Application Reference: Y/9/25/DOC Site Name: Fleurie Nursery Lake Lane Barnham PO22 0AL	Initial Issue Date: 21/02/2025 Issue Date: 19/11/2025 Reviewer Reference: ADC/EXT5/AF
--	---

ADC Drainage Comments	ADC Drainage Comments	ADC Drainage Comments	Designers Response	
Date:	21/02/2025	30/06/2025	17/11/2025	09/12/2025	
Condition Number: 4 - surface water drainage scheme

DRAWN	KCK	ENGINEER	TZ	CHECKED	CS	APPROVED	CS
DATE	DECEMBER 2023	SCALE @ A1	1:200				
JOB No.	C2904	STATUS	P	DRAWING No.	101	REV.	P4

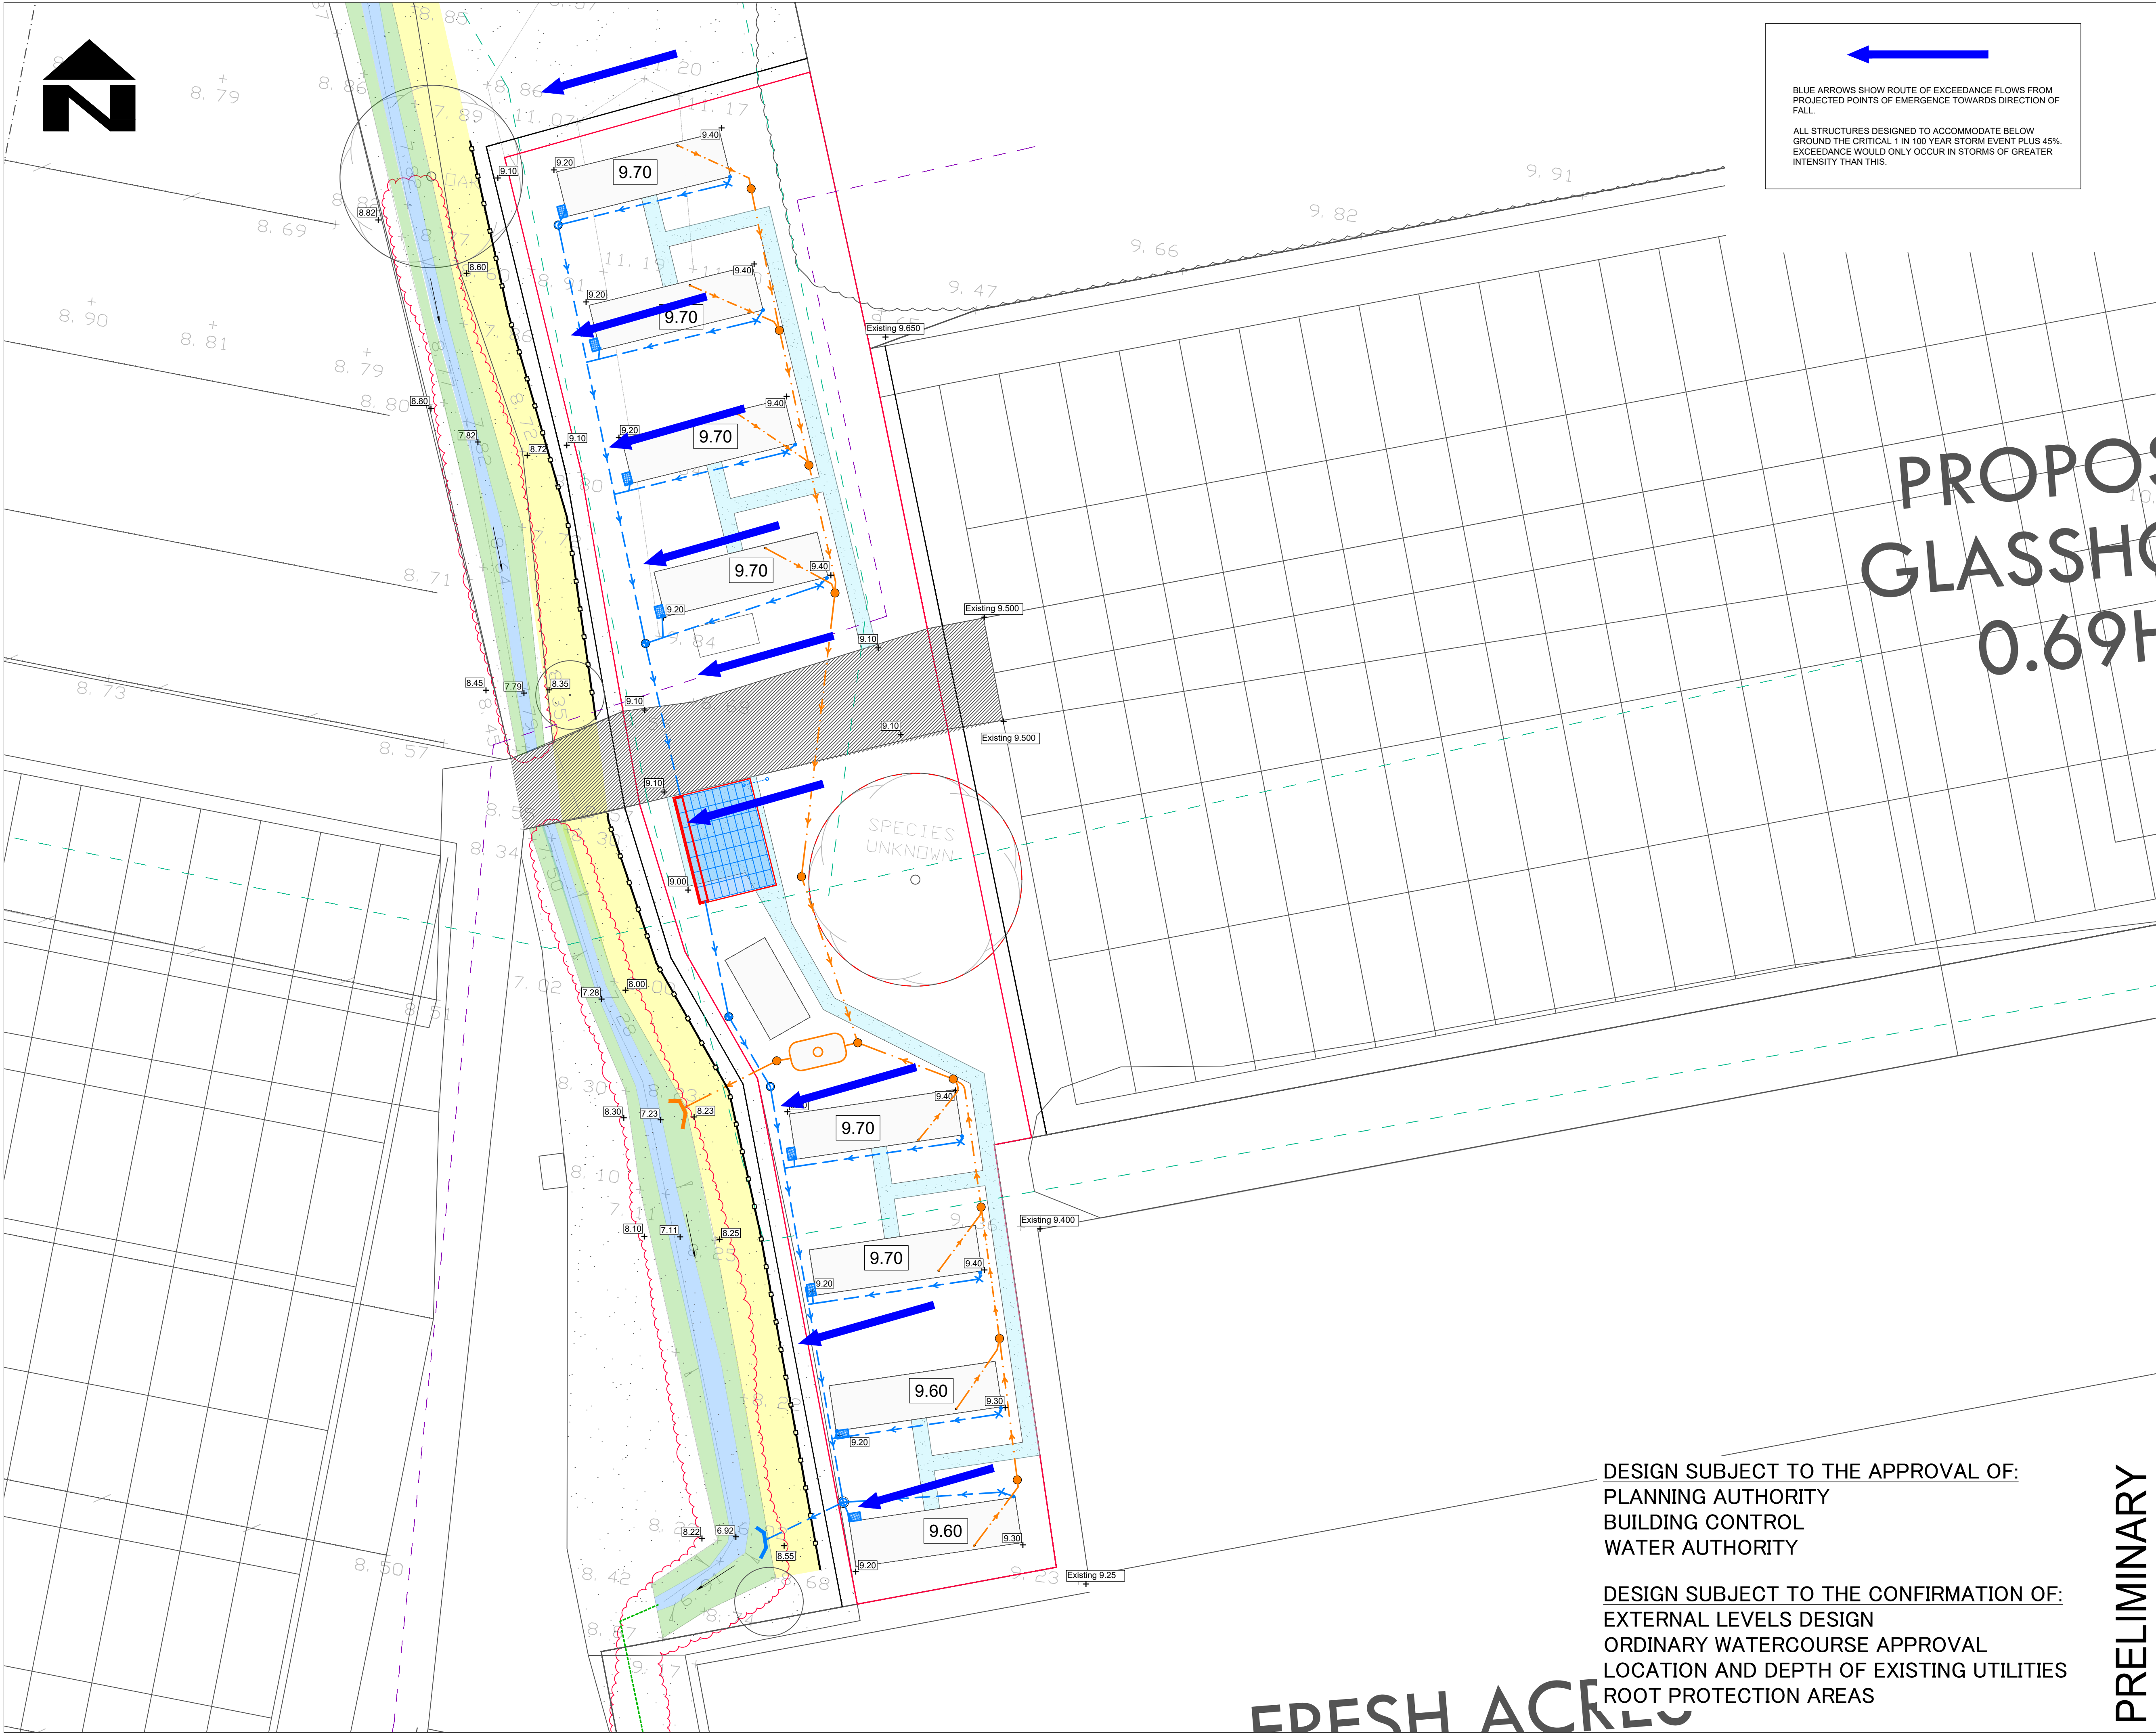
4.	Please correct discrepancies between cover and invert levels on the plans and the calculations. [It is acknowledged that this is unlikely to affect the design.] Designers response 26/03/2025 Discrepancies are now updated, please find the revised drainage plan and drainage calculations attached.	Cover levels for S3 and S4 differ. Please adjust. Designers response 01/09/2025 Updated	Drawing revision C2904 P101 rev P5 acceptable. Comment closed.	COMMENT CLOSED

5.	Please correct the impermeable area contributions in the modelling. Currently less than described on the plan due to rounding down. The southern areas are also shown entering the system at S4 which is an inaccurate representation. If grouped together then they should be showing as entering at S5. Designers response 26/03/2025 Please find the updated drainage calculations attached with impermeable areas being added to drainage nodes.	Noted and accepted. Comment closed.	COMMENT CLOSED

6.	Please show any relevant easements on the plans. Designers response 26/03/2025 The existing watercourse 3m easement is now indicated on drainage plan	Noted and accepted. Comment closed.	COMMENT CLOSED

installed post-development to protect the rife. Please clearly demark this fence on the plans and ensure that is not within the easement for the watercourse. Designers response 26/03/2025 The proposed post and rail fence is now indicated on the proposed drainage plan. Proposed fence is to be located min. 3m away from the top of the banking (easement).				
10.	The existing access appears to be artificially raised (previous level 8.55, proposed level 9.10). This is also an area of surface water flood risk – see comment 7 – please justify the change in level and demonstrate any impact on flood risk. Designers response 26/03/2025 As per the response to comment 7, access road is to raised to meet the proposed site levels. Access road will be graded following the existing site levels with a slope toward the existing watercourse to mimic the	Noted and accepted. Comment closed.	COMMENT CLOSED

existing runoff discharge regime.				
11.	The orifice for S5 is described on the layout as being 500mm diameter. This is assumed to be a typo (confused with the chamber diameter), please correct. Designers response 26/03/2025 Orifice chamber diameter has been updated to 600mm diameter and orifice diameter to 20mm.	Orifice chamber is shown as 900mm diameter. 20mm orifice noted. Comment closed.	COMMENT CLOSED		
12.	The modelling does not include the flap valve. Designers response 26/03/2025 Flap Valve is now included	Noted and accepted. Comment closed.	COMMENT CLOSED		
13.	Please remove the standard (non-site specific) headwall details from C2904-P-501. These contradict the OWC drawings which are more detailed and site specific. Designers response 26/03/2025 Headwall detail has been removed. It should be noted that OWC drawings have been issued	Noted. Comment closed.	COMMENT CLOSED

is to be installed with orifice filter plate.				
16.	There is a risk of a clash between the surface water and foul drainage north of S4 and west of F6. Please adjust the design, if possible, to minimise this risk. Designers response 26/03/2025 Clash has been reviewed and a separate note indicating proposed SW and FW pipes invert levels is now indicated.	Noted. Pipes are close when allowing for pipe thicknesses but achievable. Comment closed.	COMMENT CLOSED

Sel Controflow 600-900Ø Orifice Chamber

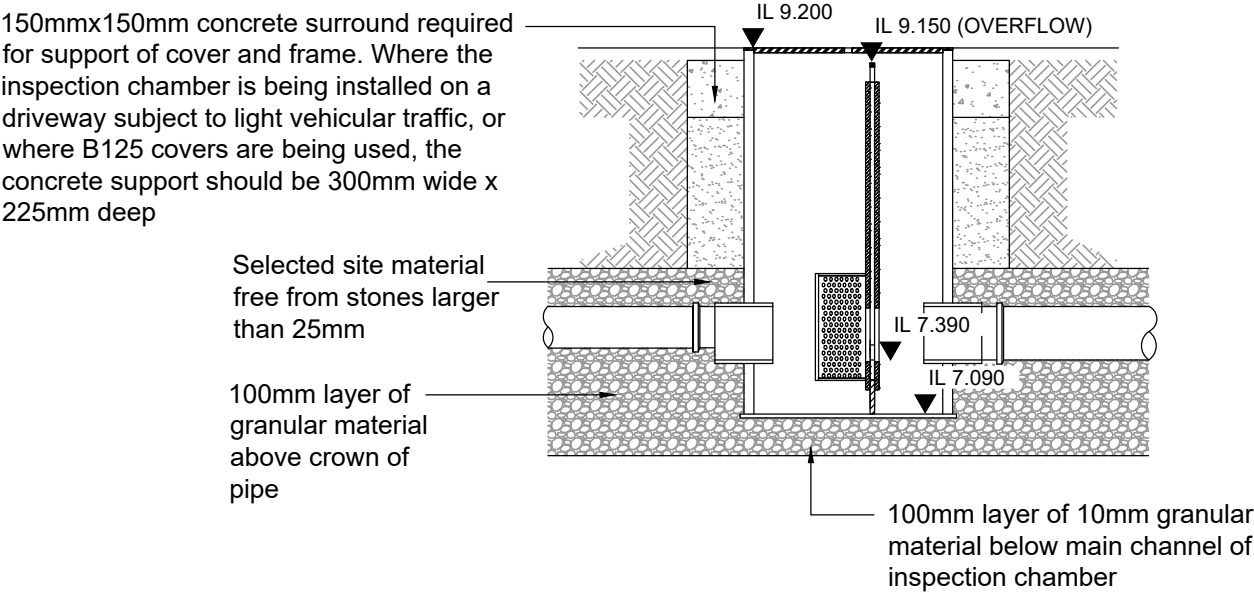
and comments have been received. Drawings are now updated and the updated drawings has been issued for final review.				
14.	Please detail the overflow level of the Sel Controflow 500 Orifice Chamber. Designers response 26/03/2025 Overflow level is now indicated on orifice chamber detail.	It is noted that the overflow level of 9.150 is higher than manhole S3 cover level (9.00) upstream, so in the event of a blockage at the orifice, excess water may overflow from S3 before the formal overflow at S5 operates. Please advise. Designers response 01/09/2025 Updated. The overflow level has been lowered and is now set at 9.025.	Drawing revision C2904 P101 rev P5 has been adjusted to show an overflow level of 9.025. The construction details drawing should be updated to suit. The construction detail for the attention arrangement should demonstrate how the vent pipe outlet will be above the overflow level, or the overflow level reduced below the cover level for the storage.	Updated.
